Fire Marshal Division

Re: Lions Den Power House Gym
4319 Ray Road
Spring Lake, NC 28390

Application Number BCOM1901-0001

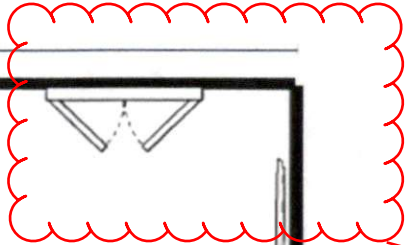
- Notes
 - Provide a Knox Box on the building if not present currently.
 - If back door is to be modified, doors must continue to swing outward.
See plan notes
 - A final fire inspection is required.
 - Schedule all fire inspections through the Fire Marshal's Office.
(910) 984-4003
